[REDACTED]
Geonrey and Jane Evans

Ref: S6/2009/2047/FP

**RE: ERECTION OF REAR CONSERVATORY AND GARDEN
SHED at OAK COTTAGE RESIDENTIAL HOME 4 WILKINS
GREEN LANE HATFIELD**

Roof Plan

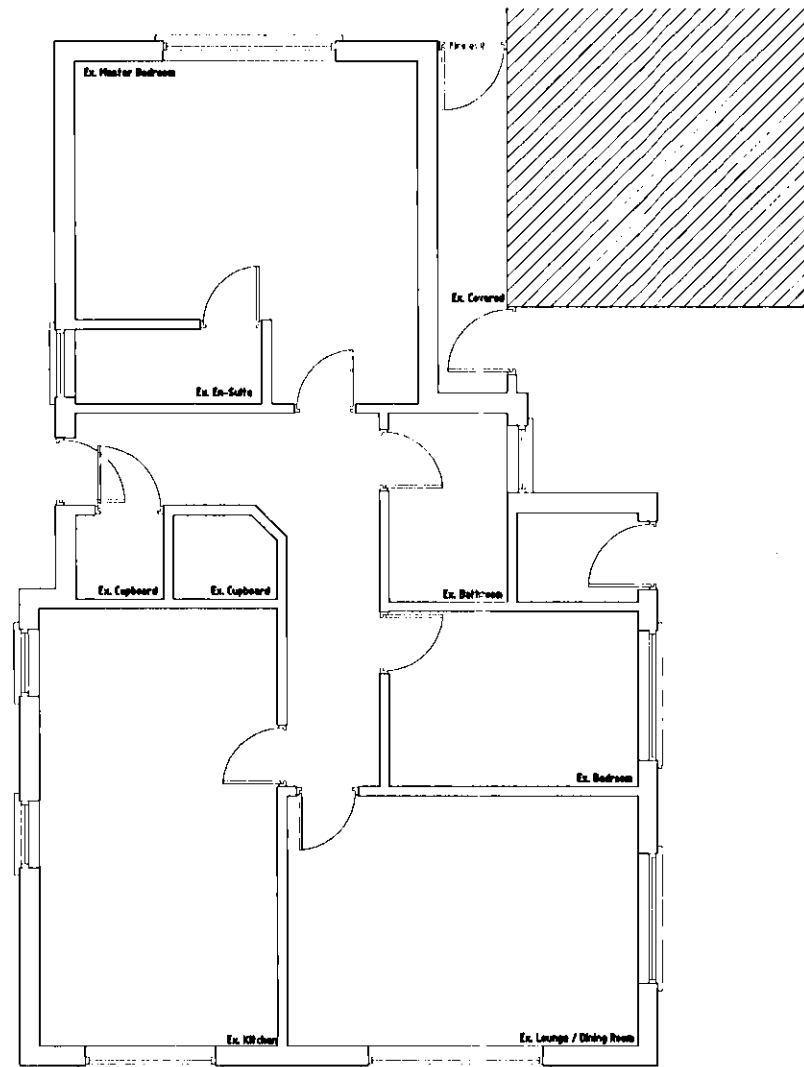
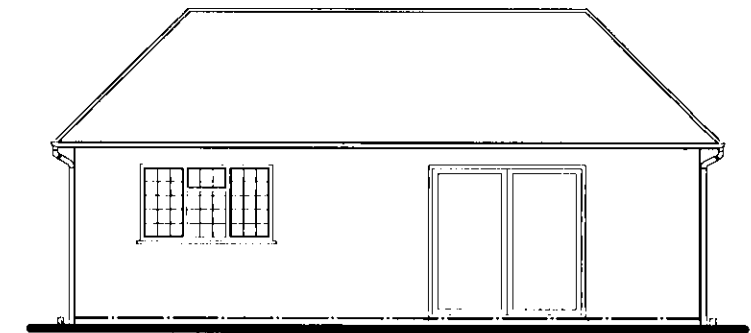
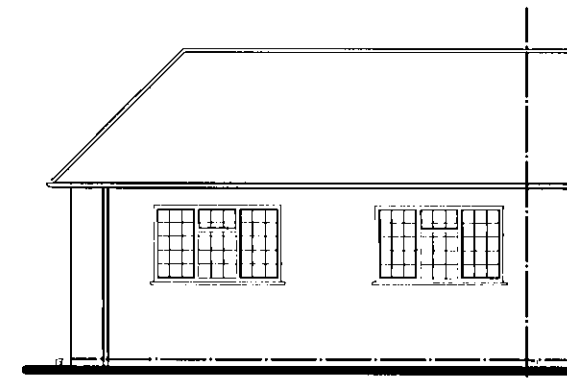
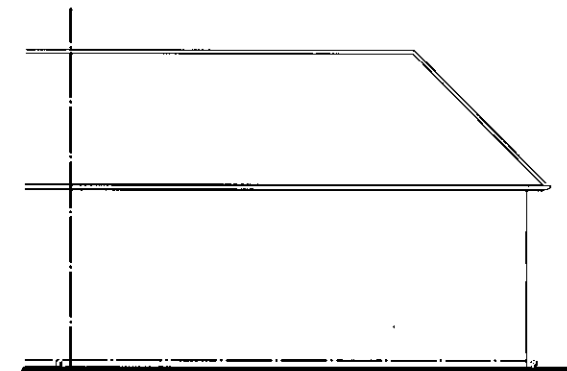
affects our light even further as there are already several large conifer trees abounding our property. This contradicts the answer in section 1 of the Sustainability Checklist in that there **IS** an impact on neighbouring properties. Please see enclosed photographs.

5). My understanding of a garden shed is that it is a wooden construction which can be moveable. This building clearly is not moveable.

6). The application states that the finish on the exterior walls is to be white render. This is **NOT** acceptable. If it is a "Garden Shed" it should therefore look like one and be wooden clad and suitably stained so that it blends into the environment. We are the ones who would have to look at it after all.

8). The "Garden Shed" should be demolished and if necessary re-sited elsewhere on the property at a much more acceptable height and where it does not impact on others.
